London Luton Airport Expansion

Buckinghamshire Council Response to the Applicant's Response to Deadline 6 Submissions 6

PINS REFERENCE: TR020001

January 2024

Figure 12 - 2043 With Expansion (32mppa) Passenger Trip Distribution

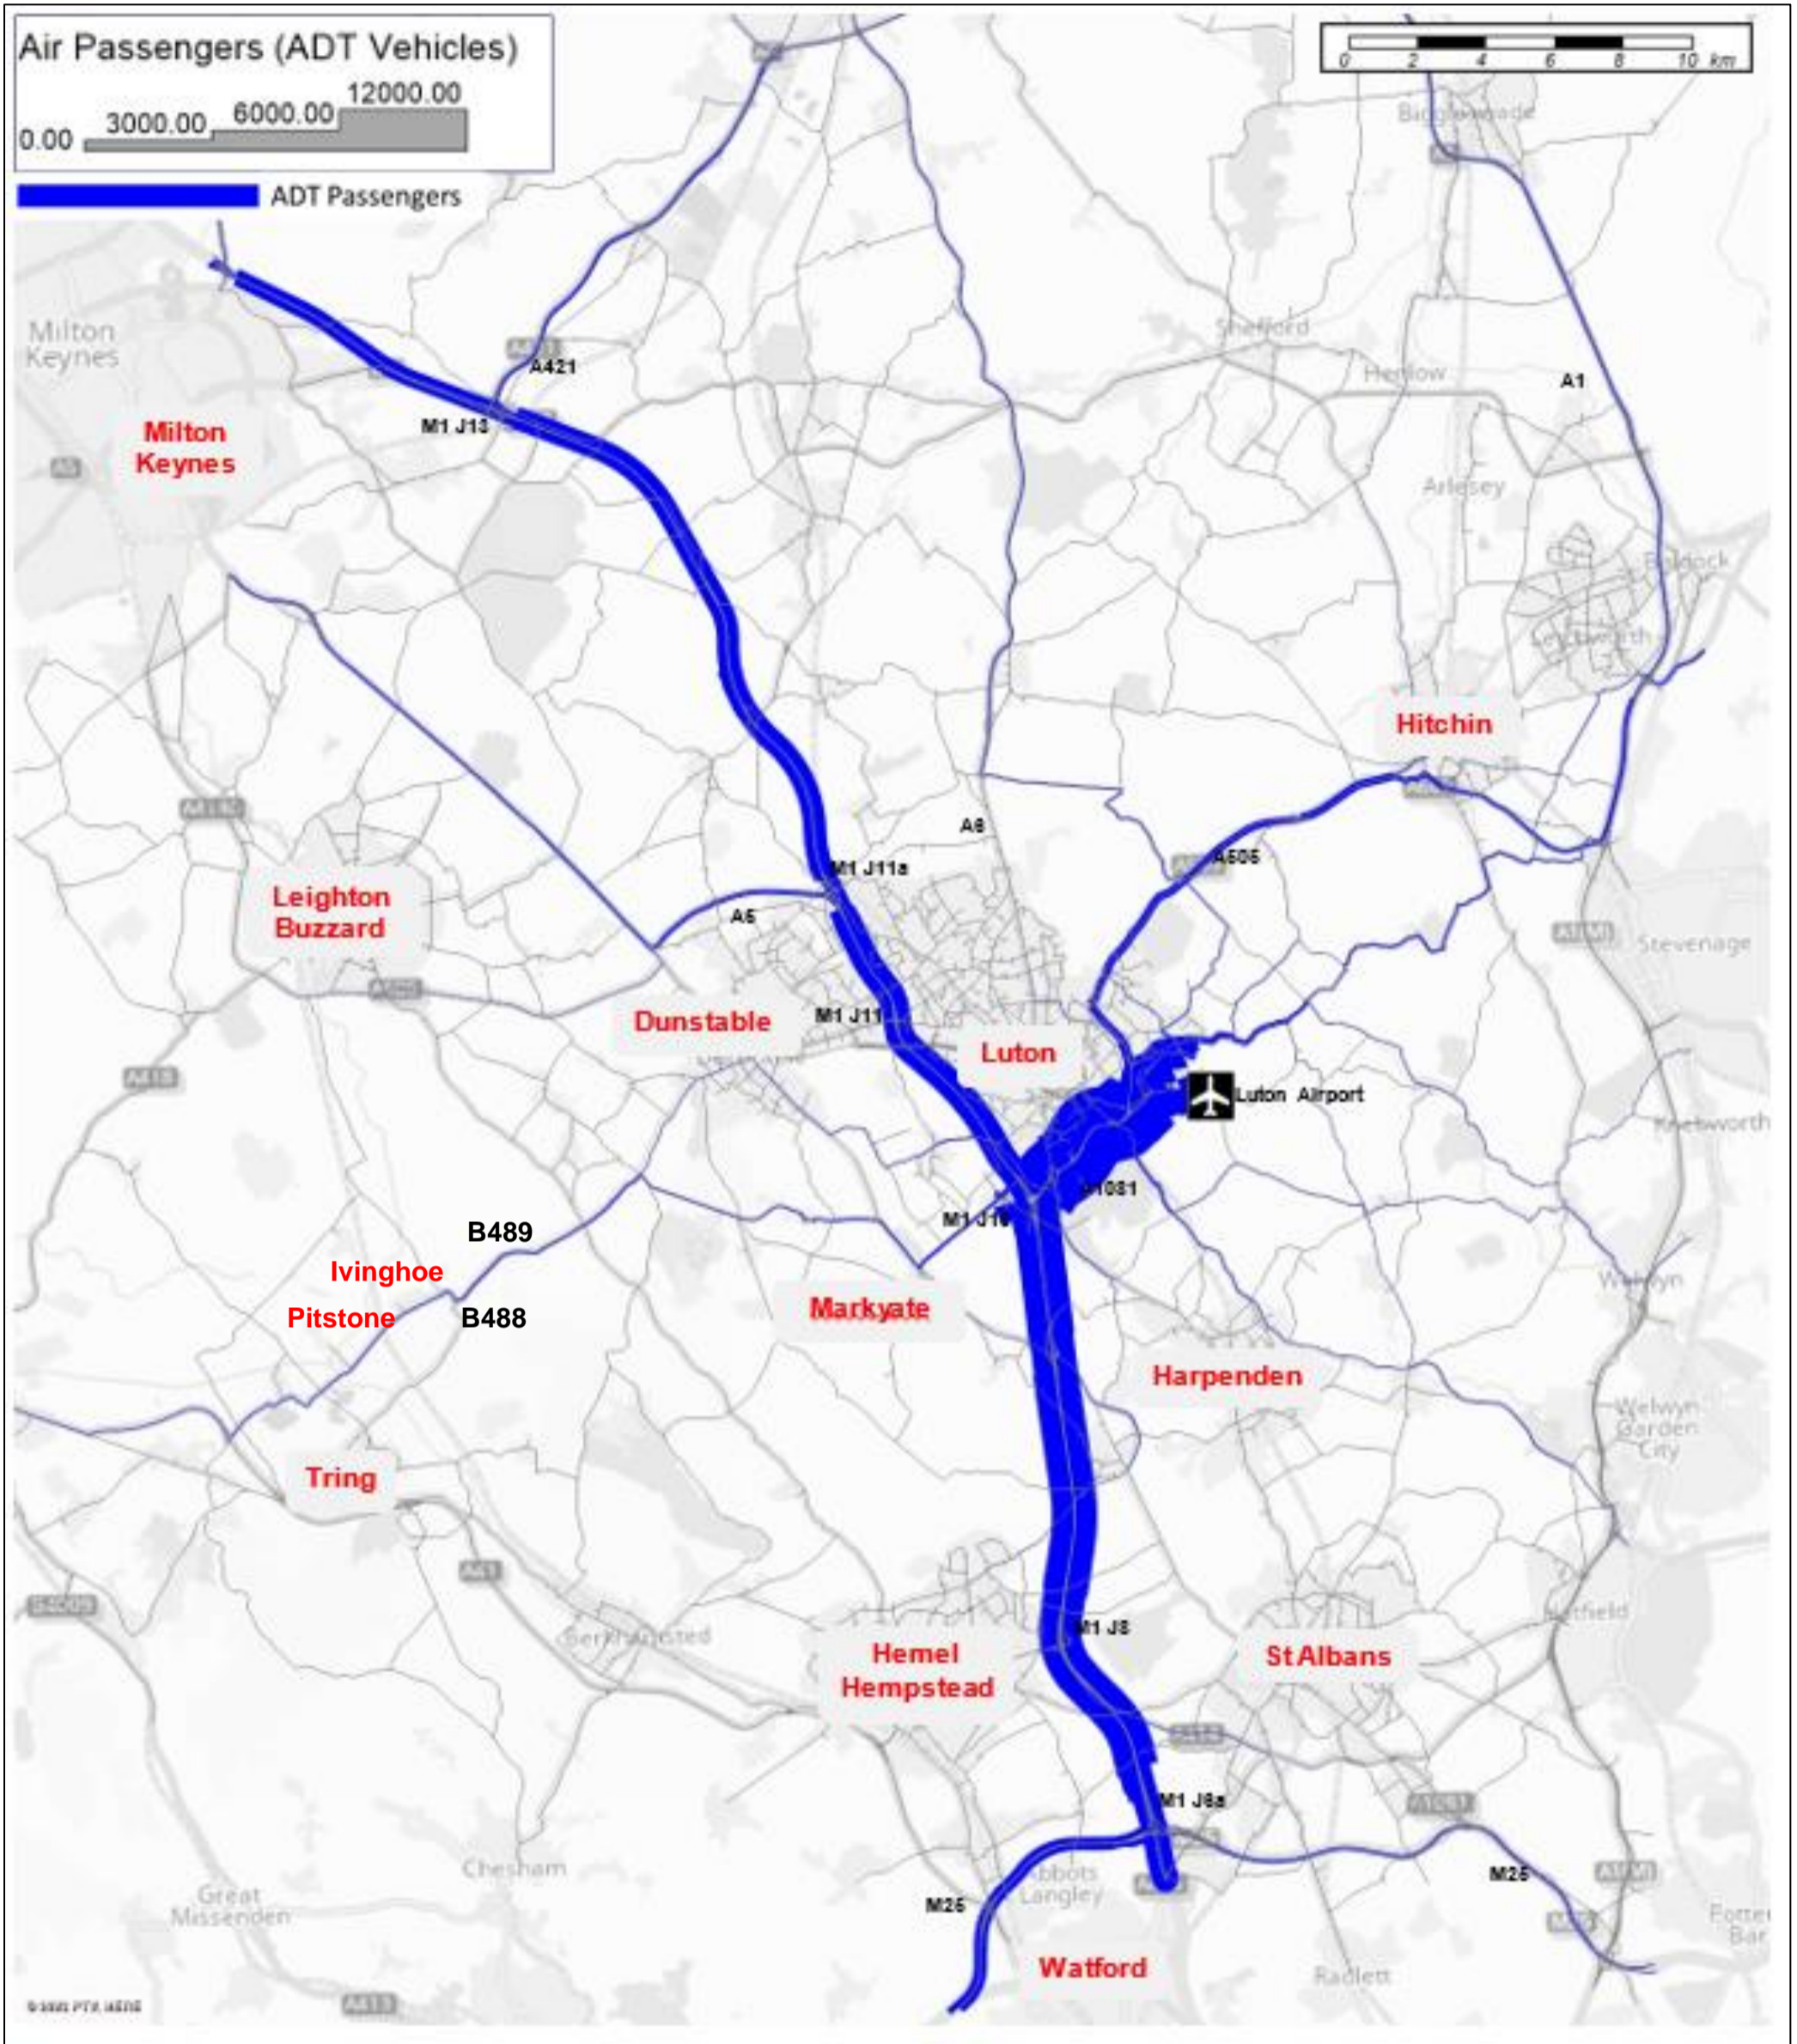
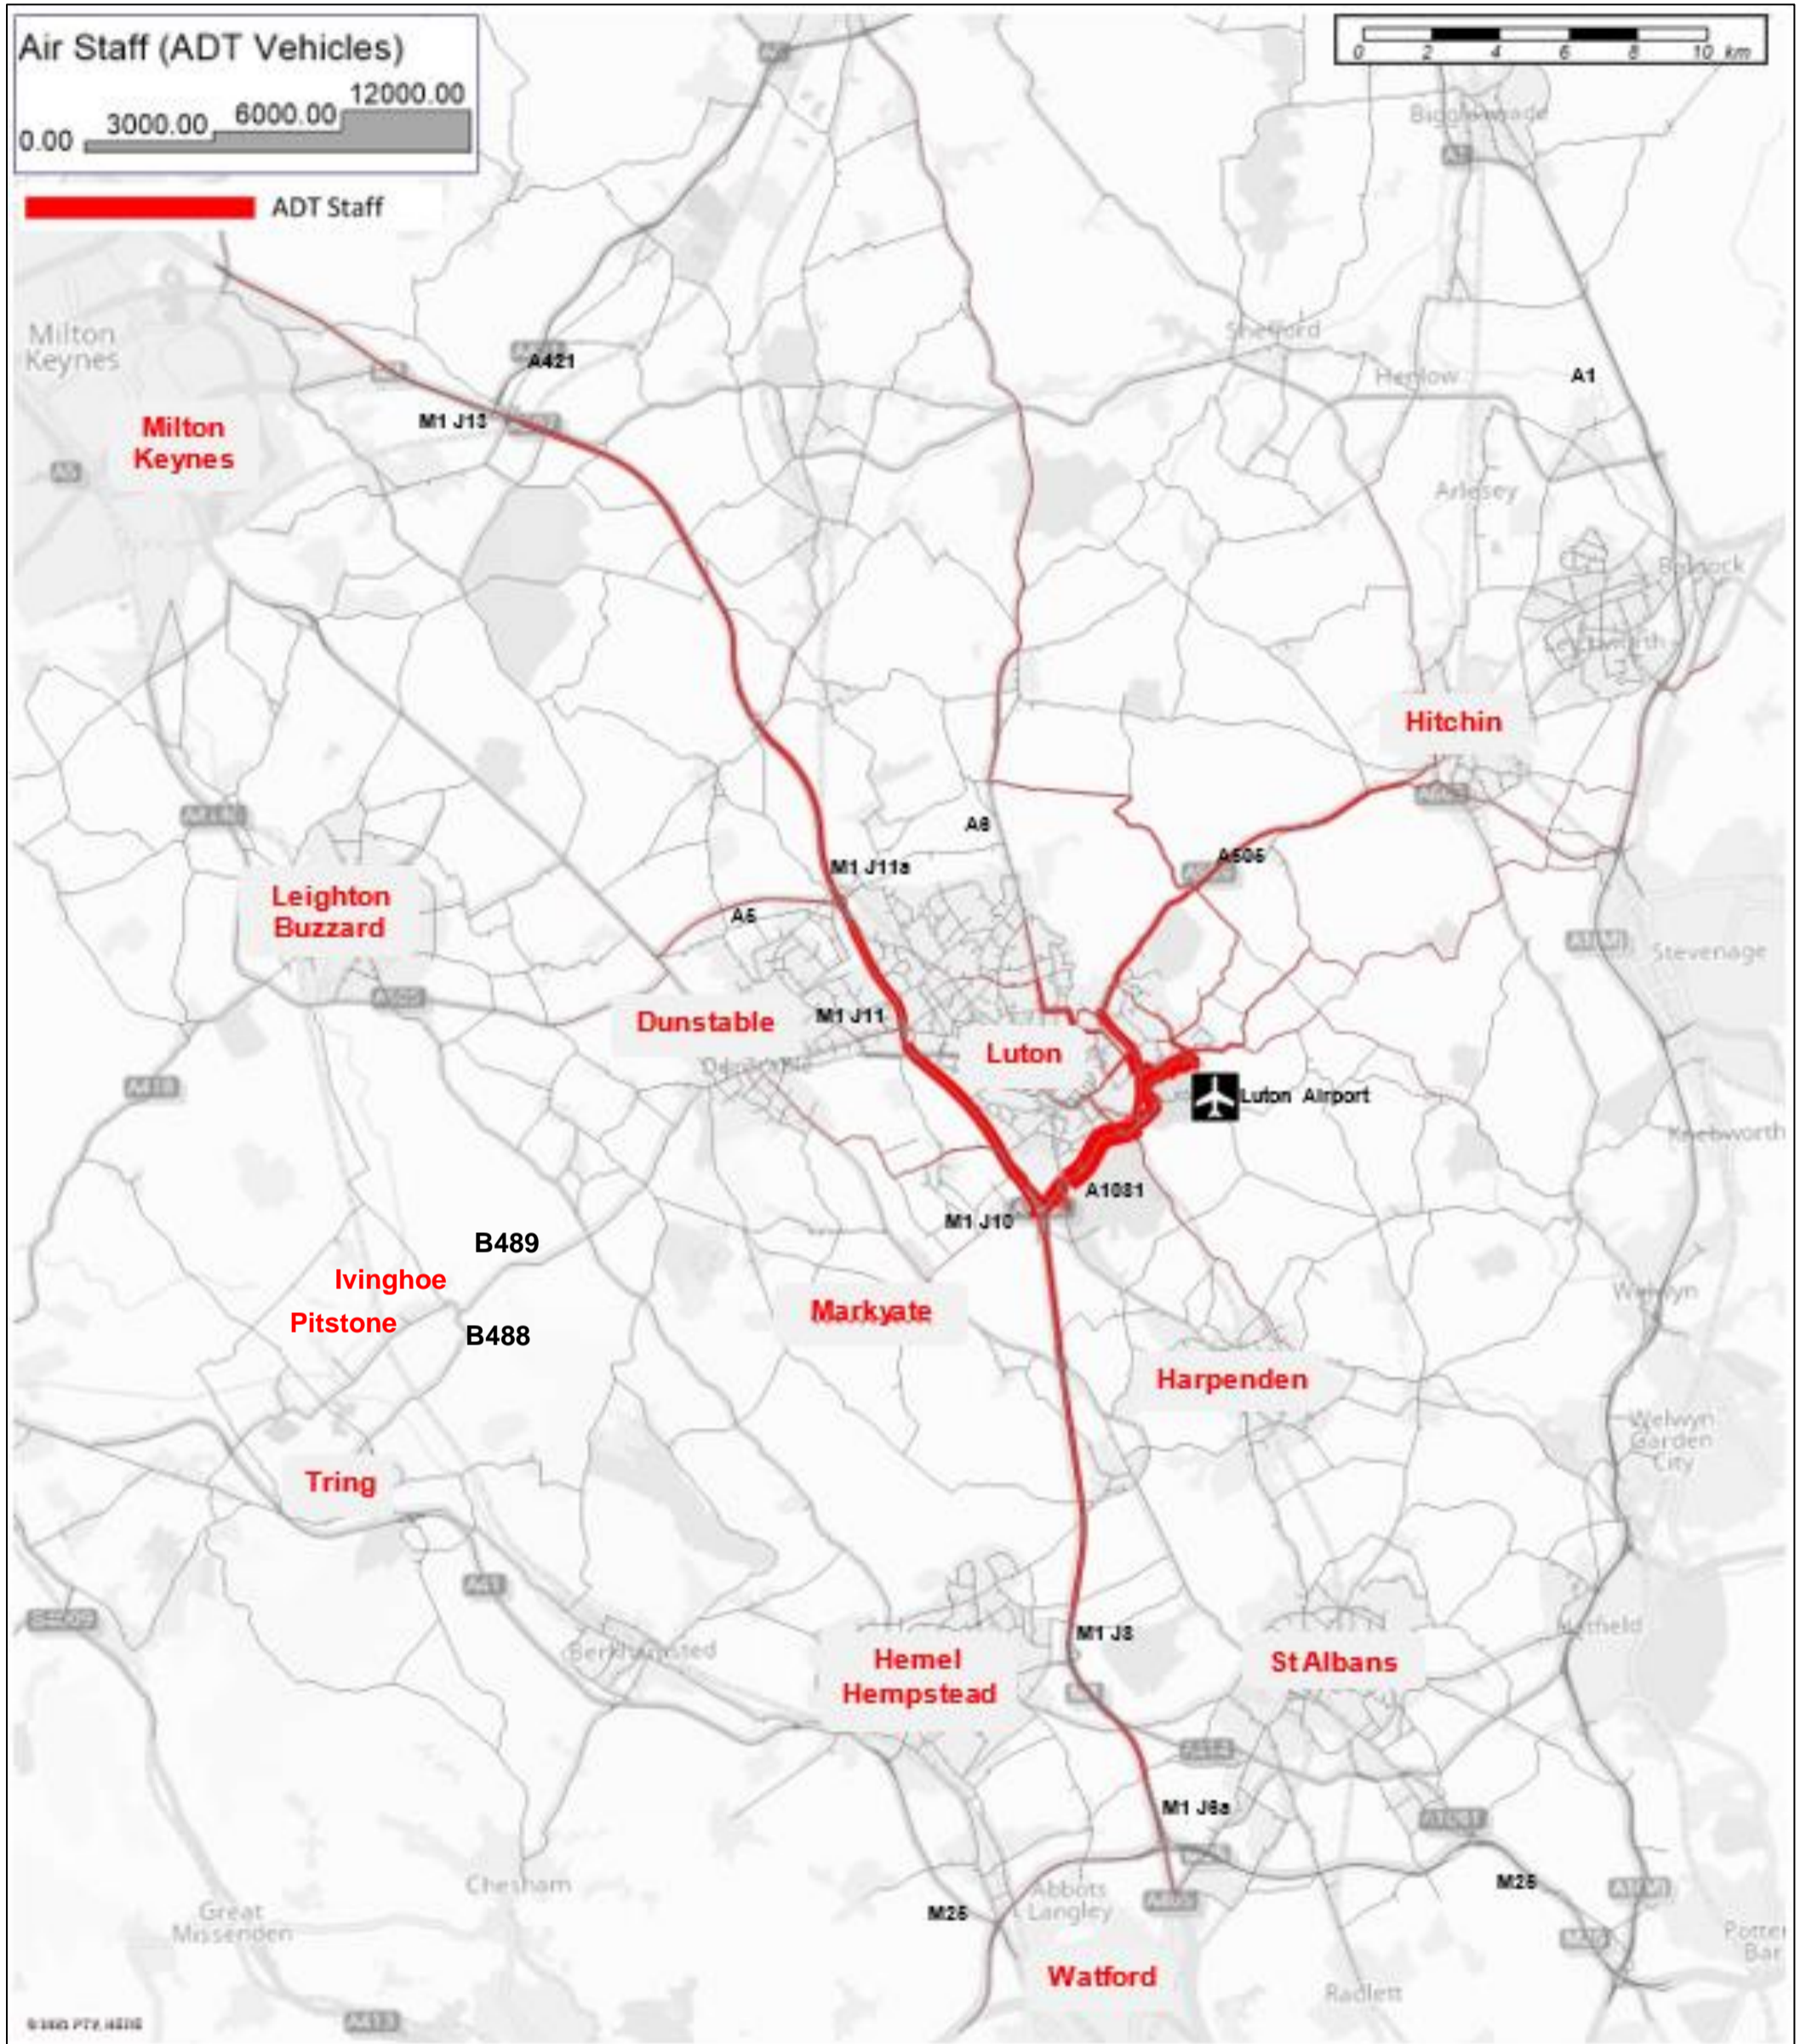
<p>3.4 Surface Access</p>	<p>Ivinghoe junction The Trip Distribution Plans [REP5-037] show that the west east corridor is an important route from the west to the airport. The routes through the villages are not well suited for such usage, which vehicles passing through locations that will be sensitive to relatively small changes in traffic flow, with small increases in vehicle throughput leading to material safety concerns where elements of the route are inherently unsafe.</p> <p>The Trip Distribution Plans [REP5-037] demonstrate that with the expansion of the airport, greater numbers of air passengers shall use this route. This is evidenced by the 3 thickening of the difference plot line but, as stated above, the numerical data has not been supplied to quantify this impact.</p> <p>As noted by the ExA during the hearing, the model routes the traffic through the Bucks villages (Pitstone, Marsworth and Ivinghoe). That modelled prediction, despite the lack of suitability of that route in highways safety and environmental terms, justifies the relatively minor works BC proposes to the Ivinghoe junction in order to re-route traffic down the more suitable B488.</p> <p>Such changes to the priority junction at the B489 and B488 Ivinghoe would reduce traffic using unsuitable routes, protecting pedestrian and driver safety within the villages and making the main route away from the villages improves air quality within the villages. BC maintains until demonstrated otherwise that the junction priority works at the B488/ B489 junction should be included within the required works for the scheme and not left to the Council to fund at a later date, either through the</p>	<p>As mentioned in the response provided at ID 3.3 above, the Applicant acknowledges that some forecast airport trips would be travelling along the B489. However, the Applicant's view is that the forecast increase in traffic is not considered 'severe'.</p> <p>Detailed information on the forecast numerical change in traffic along the B489 is included in Applicant's Response to Issue Specific Hearing 7 Action 3 - Ivinghoe Junction Modelling Review [REP6-070]. Further numerical information is also included in relation to the Rule 9 modelling update which is reported in the Applicant's Response to Issue Specific Hearing 7 Action 2 - Accounting for Covid-19 in Transport Modelling Final Report [AS-159].</p> <p>Moreover, the Applicant discussed in the Applicant's Response to Issue Specific Hearing 7 Action 3 - Ivinghoe Junction Modelling Review [REP6-070] the pre-existing issues along the B489 and its junction with the B488. The Applicant has not yet seen evidence to support the issues referred to, and whether they are related to capacity, safety, or health (related to early hour traffic), and more importantly how a relatively small increase can lead to material concerns.</p> <p>The Applicant also notes that the proposal to re-prioritise the B489/B488 junction could potentially divert traffic onto the B488 and Tring, within the Hertfordshire road network without consultation with that highway authority that the Applicant is aware of.</p>	<p>As above, in addition, BC is aware that movement of traffic to the B488 would lead to traffic travelling through Tring. It is however the Council's position that this is currently the official signed route and properties on the B488 are set back from the carriageway with gardens and hedges. The B489 has properties abutting the carriageway with no buffer to residents being impacted by noise or increased traffic impacts. It therefore remains the Council's position that increases in traffic should be kept by all practical means on the signed route and not through the villages on the B489.</p>
